Engineers Comments Regarding Surface Water Drainage

Application Reference:	BN/24/26/DOC	Reviewer Reference:	ADC/EXT2/94
Planning Officer:	Amber Willard	Date of Review:	26/03/2026
Site Name:	Land South Of Wandleys Lane Eastergate PO20 3SE		
Application Description:	Approval of details reserved by condition under BN/46/25/PL relating to conditions 4- Surface Water Drainage and 5- Foul Water Scheme.		
Assessment Number:	2 of 2

Application Reference: BN/24/26/DOC Site Name: Land South Of Wandleys Lane Eastergate PO20 3SE	Initial Issue Date: 26/03/2026 Issue Date: 26/03/2026 Reviewer Reference: ADC/EXT2/94
---	--

Controls within Manhole PS5-DIF

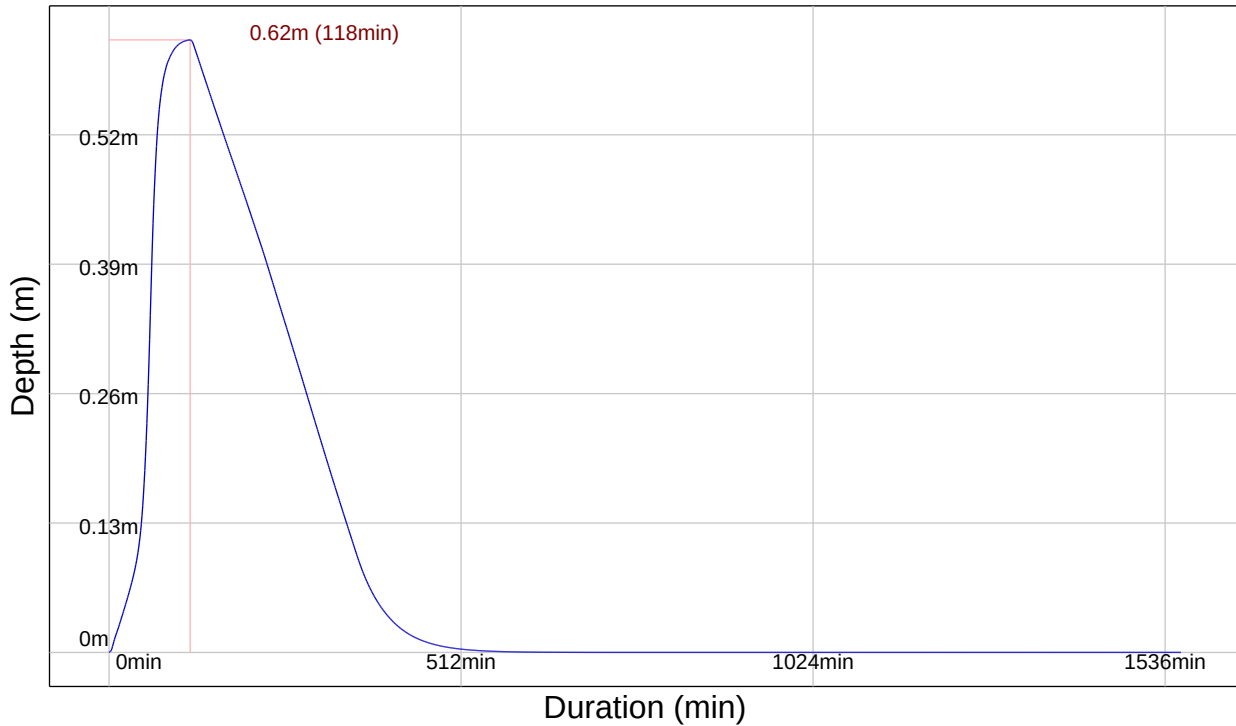
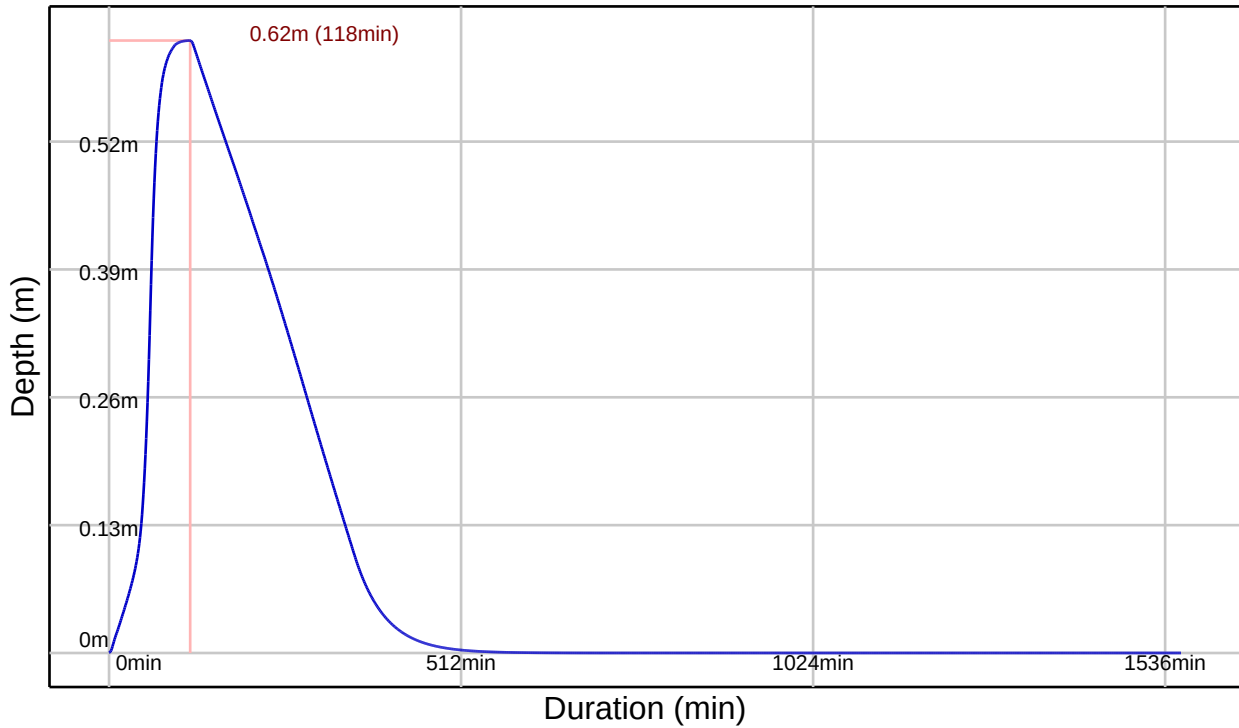
31.			Please demonstrate that it is possible to construct a rodding eye with a depth to soffit of 250mm		
32.			A flap valve is included on the calculations at PS5dif. Please confirm what this is for and if it is necessary provide details on the drawings.
